2 storey infill extension to front elevation & 1st
floor infill extension to rear elevation.

39 Conway Drive Pagham

Ref Planning Application P/49/18/HH

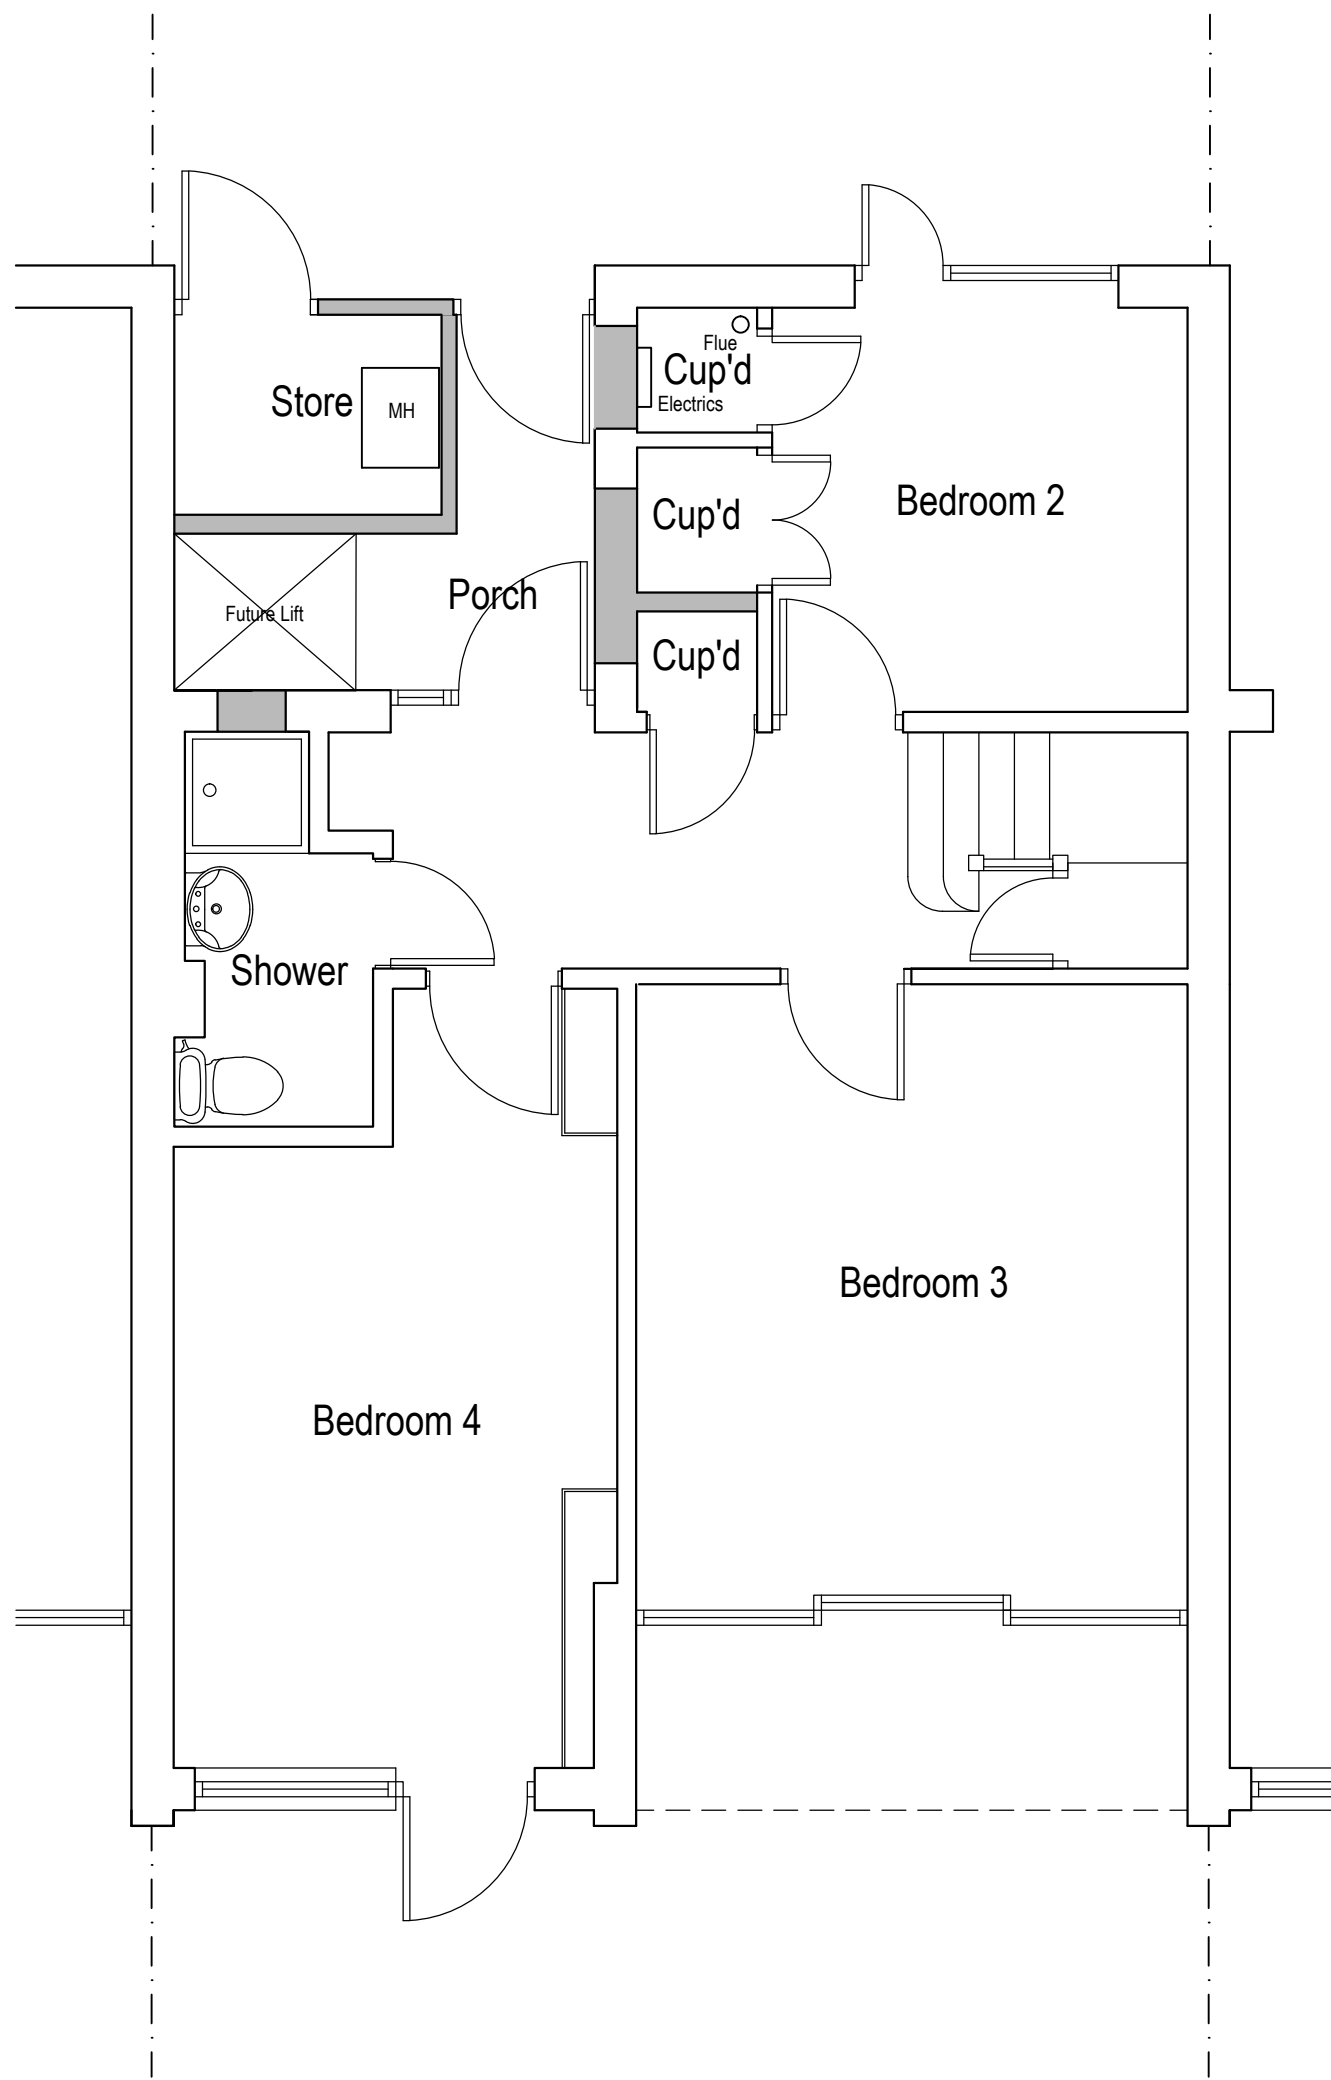
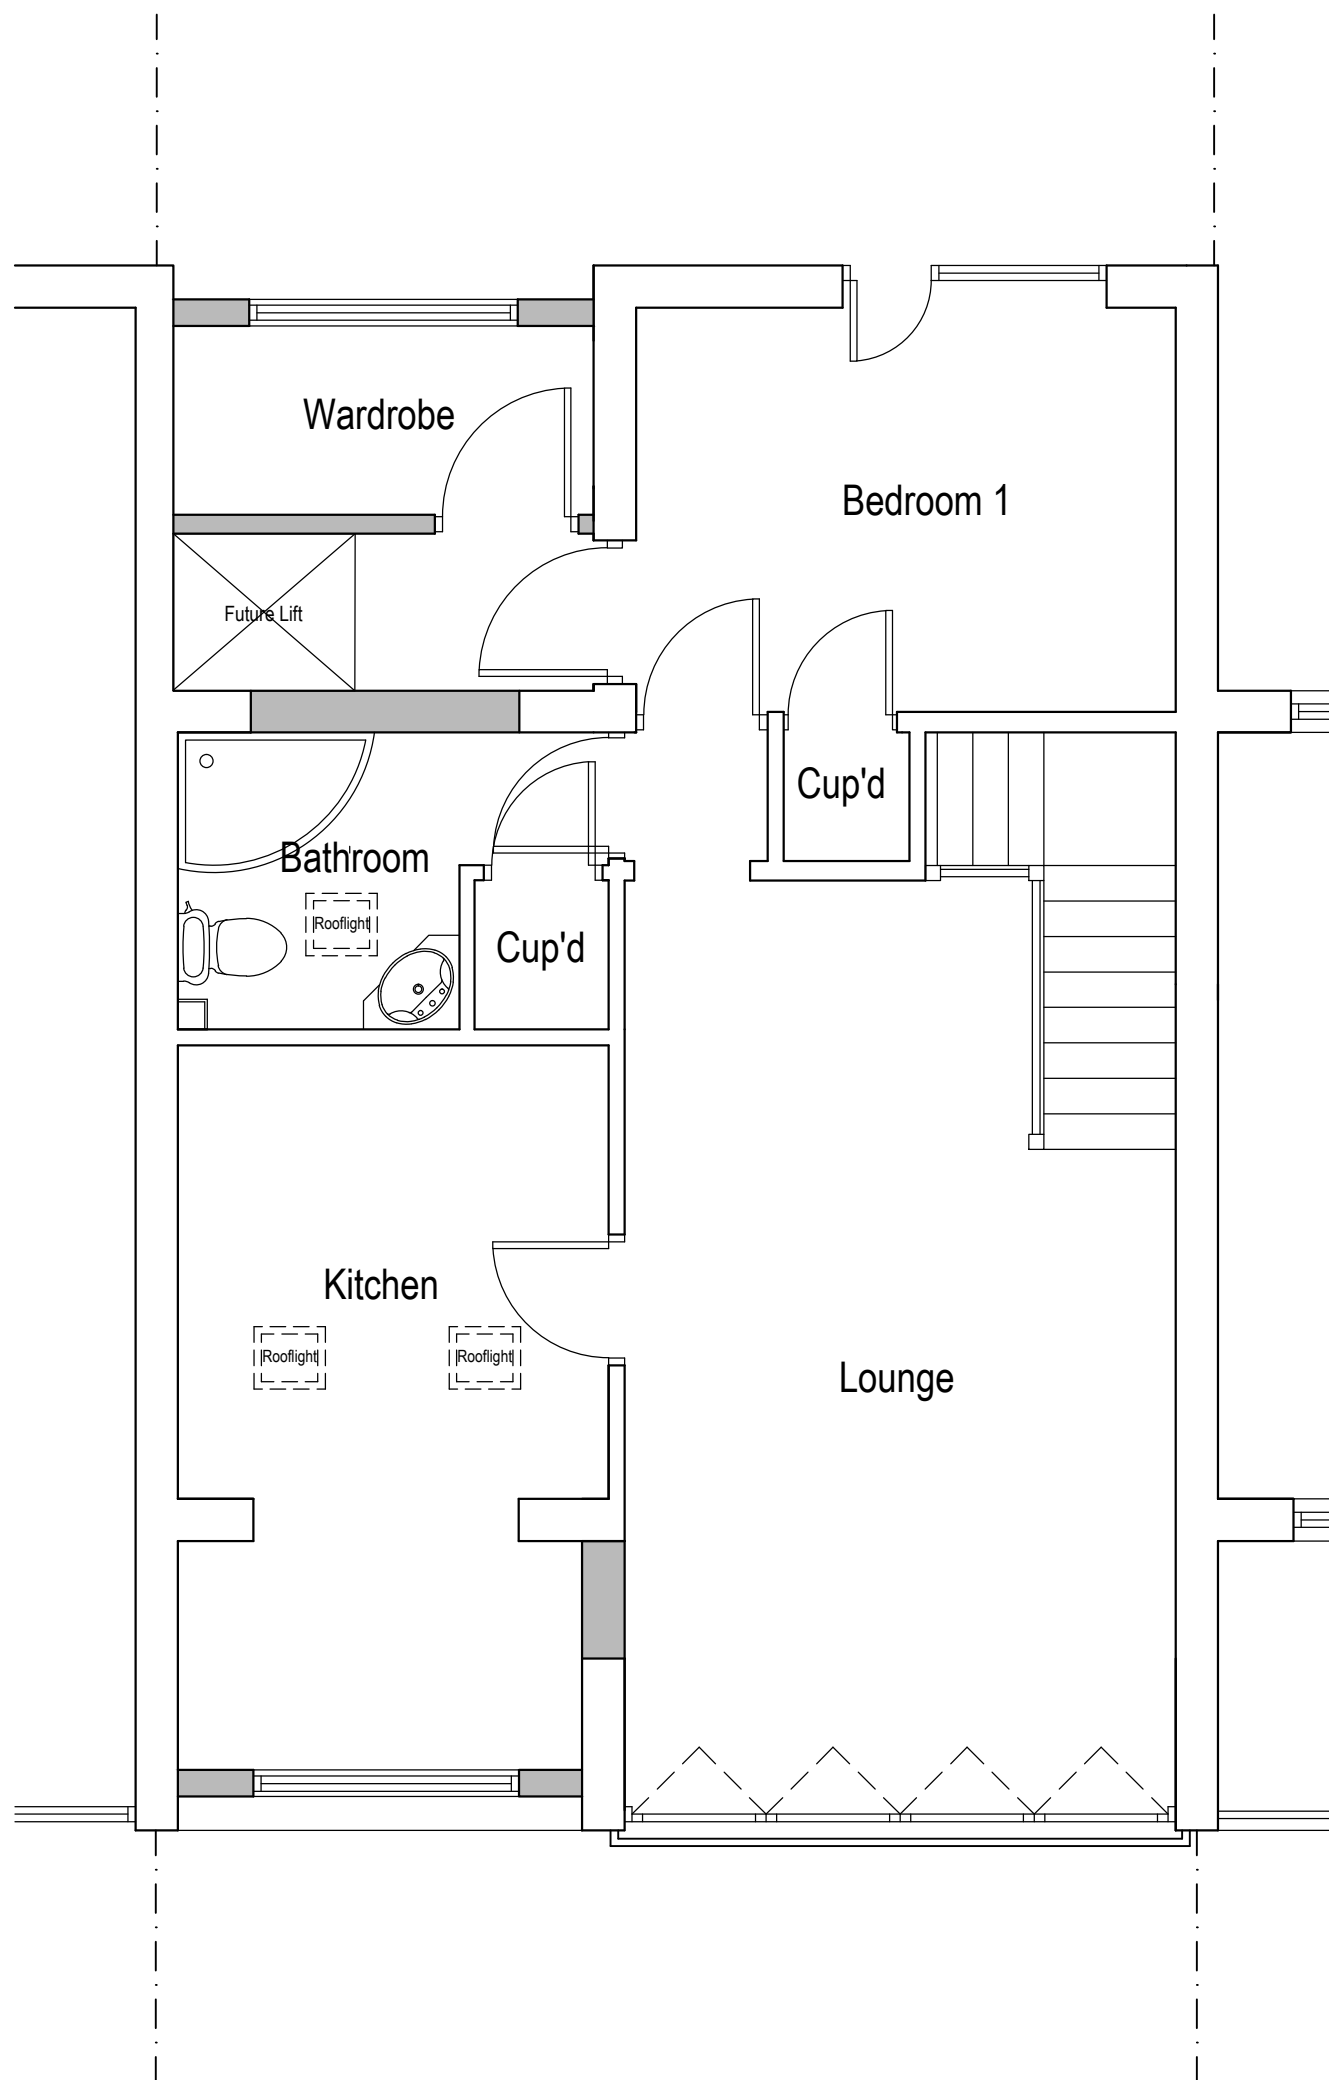
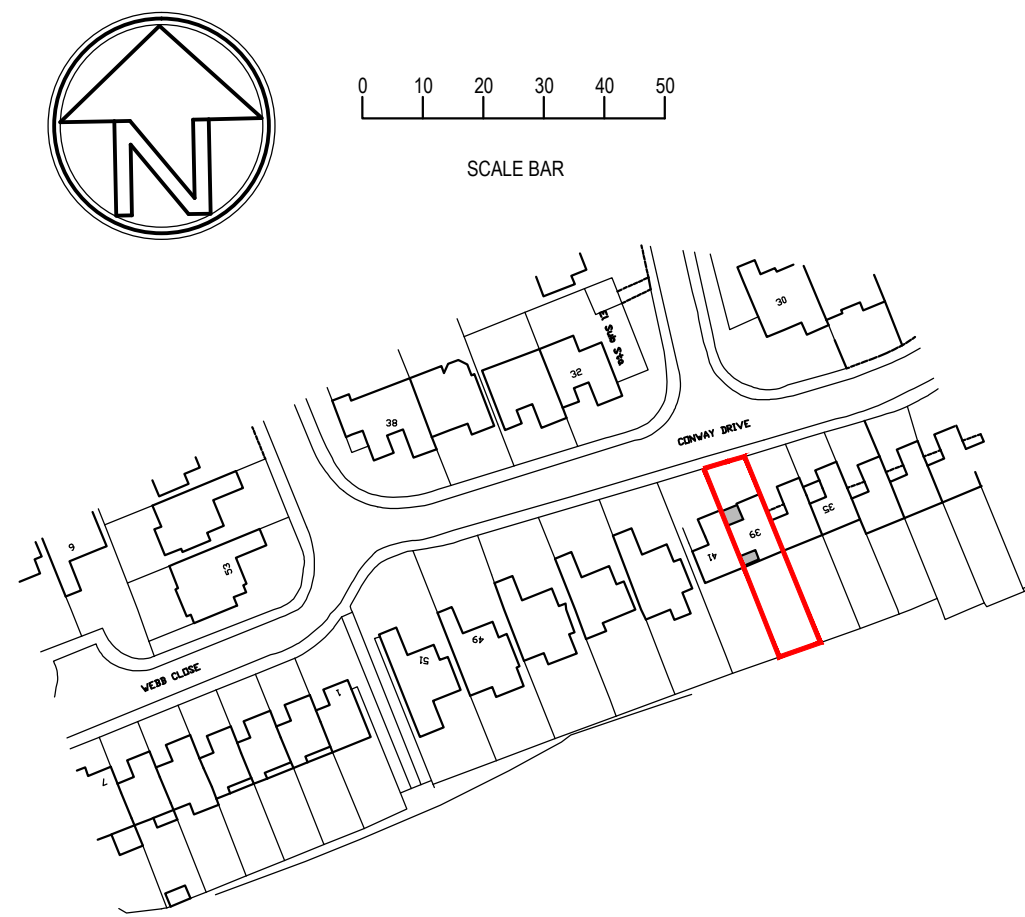
*We are living next door to the said property and believe that an extension to the front will
spoil the unique character of our 4 Scandinavian style properties, nos 35, 37, 39 and 41.*
